**Our ref:** AE/2021/125910/01-L01  
**Your ref:** \*  
**Date:** 02 March 2021

## **WRITTEN REPRESENTATIONS FOR THURROCK FLEXIBLE GENERATION PLANT.**

### **LAND NORTH OF FORMER TILBURY POWER STATION, TILBURY, ESSEX**

Figure 3.1: Baseline flow speeds during flood tide (top). Effect of AIL Facility (middle and bottom).

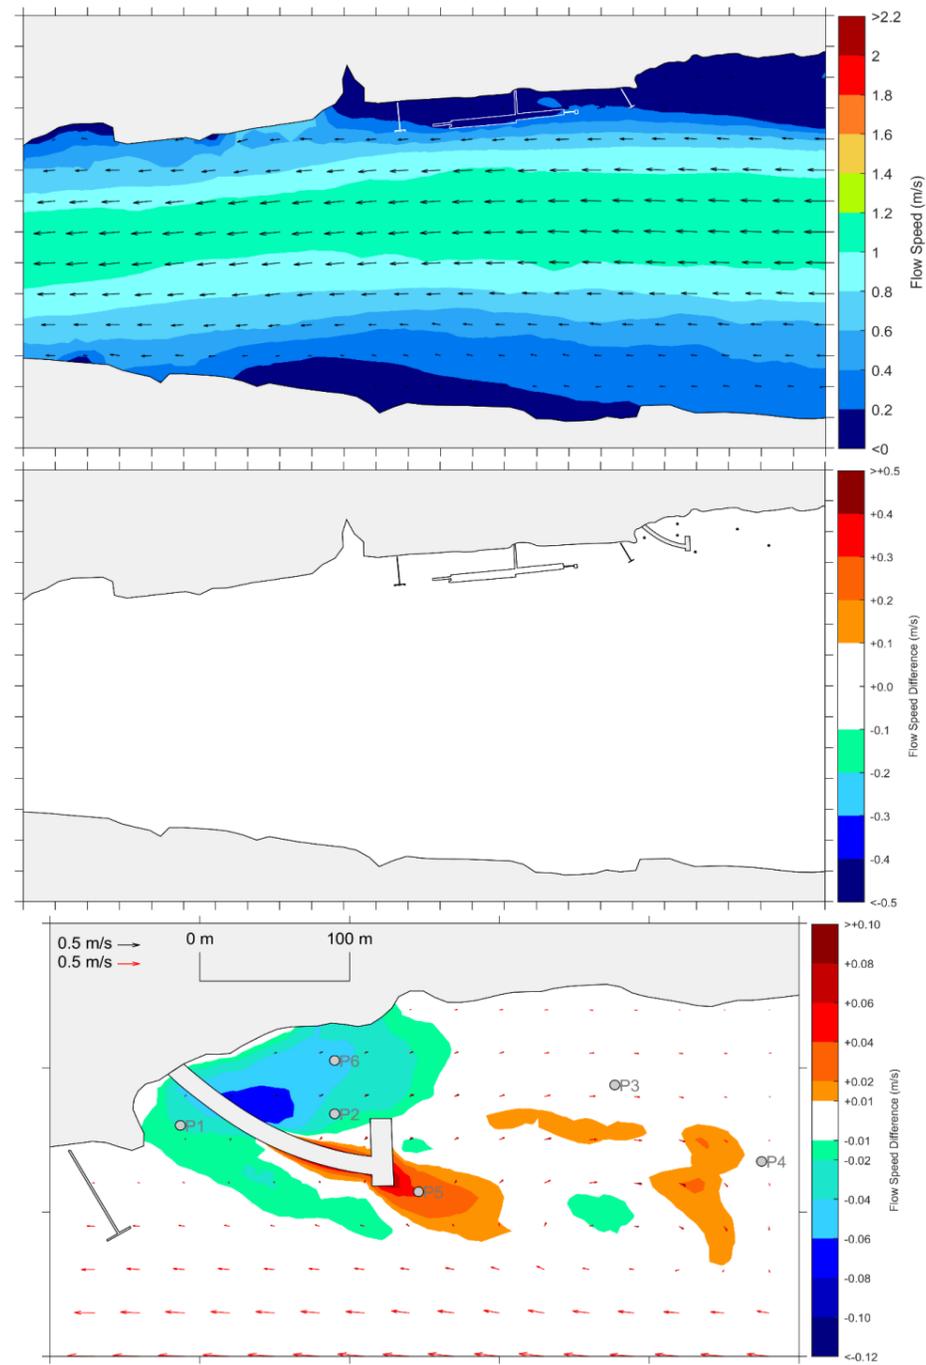
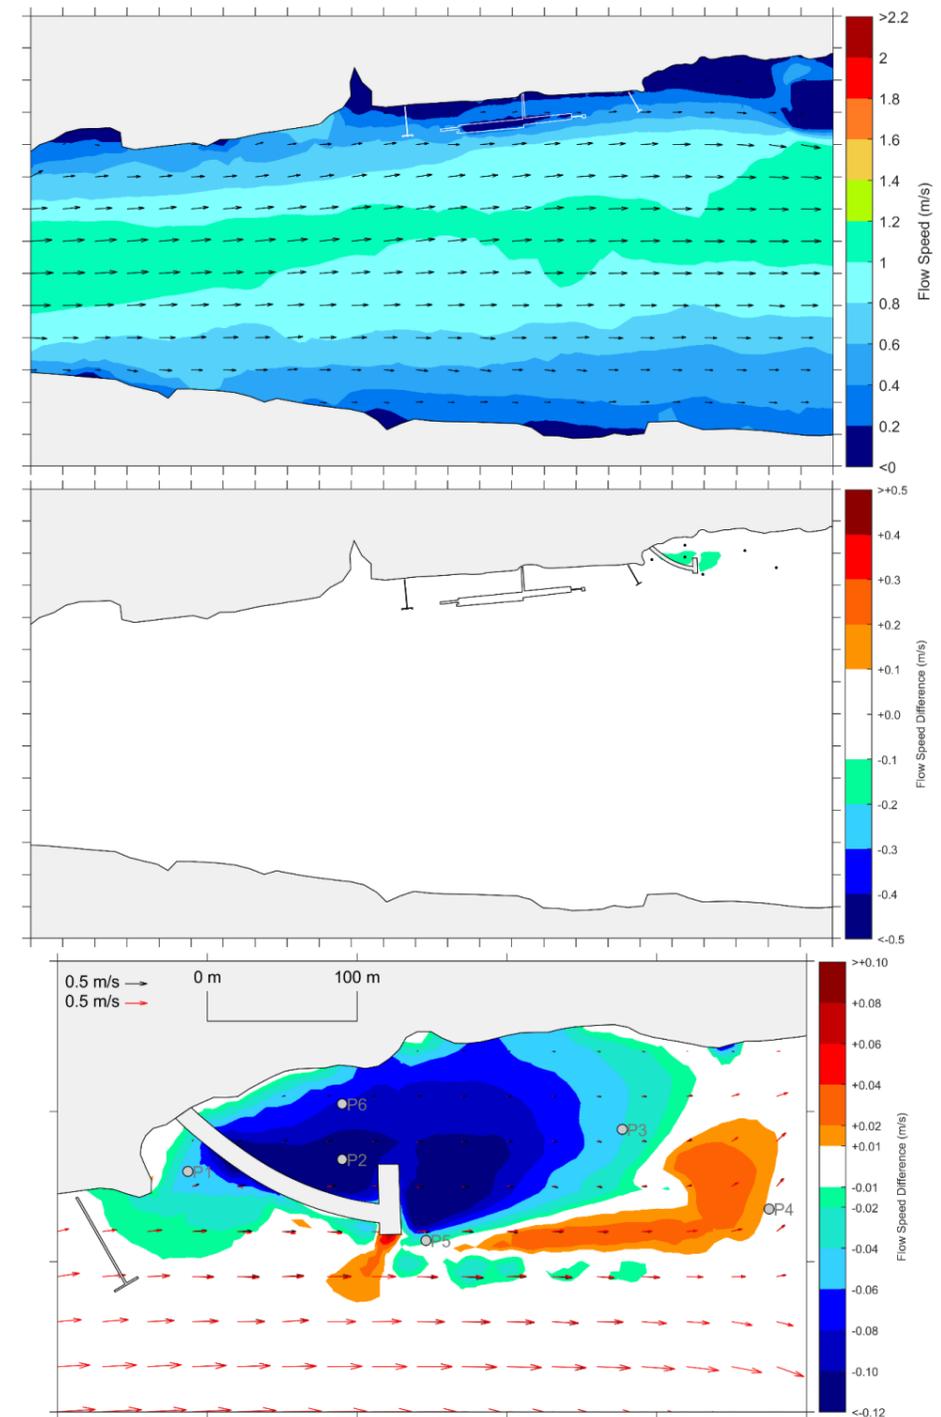
9.3 Chapter 4.1.31 states: 'The habitat loss/disturbance related to dredging activities and impact on marine ecology receptors is temporary and reversible, being limited to the construction phase only, with sediments expected to infill the vessel grounding pocket within months to a few years following the construction phase'. There is no evidence of how long the existing inter-tidal mud habitats have established on this stretch, and therefore the length of time for the associated fauna to re-colonise and utilise this habitat. The submitted assessment is unclear if this would take months or years for the layers of inter-tidal mud to re-establish. Even if the dredge pocket does re-establish very quickly, the development proposes to retain the use of the causeway. Therefore there will be a certain amount of perpetual disturbance of this site, by future dredge operations and so is not a temporary effect.

9.4 We don't agree that the total loss of inter-tidal area including the dredge pocket represents an insignificant effect. Whilst in terms of the size of the Thames it is small, at the local level of this reach of the Thames, this represents a stretch of inter-tidal area that has little disturbance. In turn this represents a significant change for this immediate environment.

Figure 1.1 Proposed causeway structure.

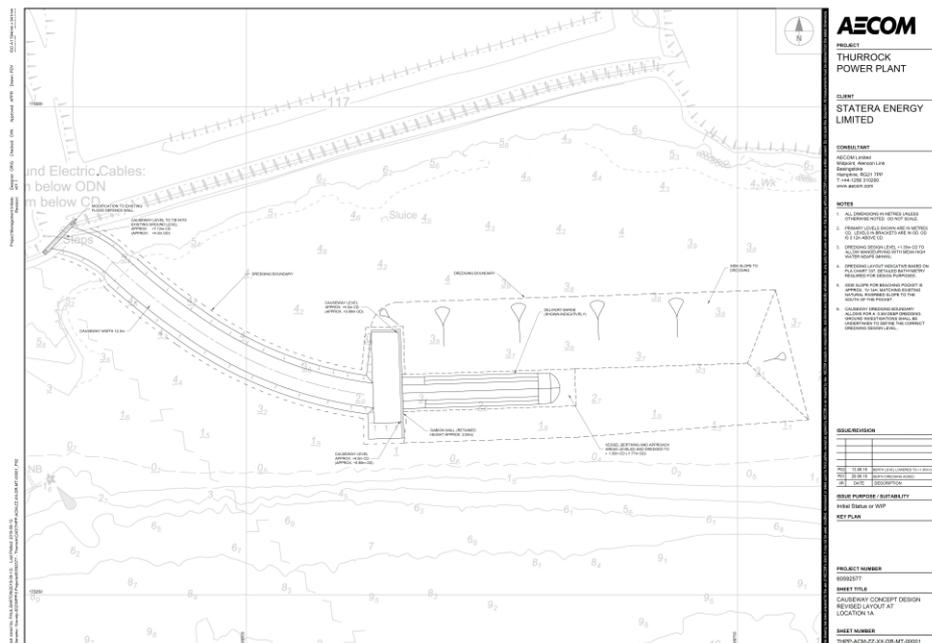
8.1 We have held pre-application meetings with the applicant regarding their plans for building a causeway across the flood defences as part of their development. Whilst we do not object to this in principle, insufficient information has been provided on how the integrity of the flood defences will be maintained, and how construction of the proposed floodgate will be achieved. We would require further information to be in a position to agree to this. We are prepared to work with the developer in the production of their plans.

9.2 The application proposes not to remove the causeway at the end of the development. We do not agree with this approach and believe the structure should

be removed, and the requirements of any future scheme on the site should assess the need for a solid structure compared with an open pier/jetty design that does not require a loss of habitat. We feel there should be a long term commitment to removing the structure, when it becomes obsolete and unnecessary, rather than retaining it, unless compensatory inter-tidal habitats for the loss of mudflat, in a suitable location within the Thames estuary, has been achieved. We do not feel that relying on the accretion of materials around the causeway will lead to habitat creation, as it is uncertain what will develop and what could be retained beyond the 35 year life time. However we do note that the status of the causeway will be reviewed every 5 years and we welcome this.
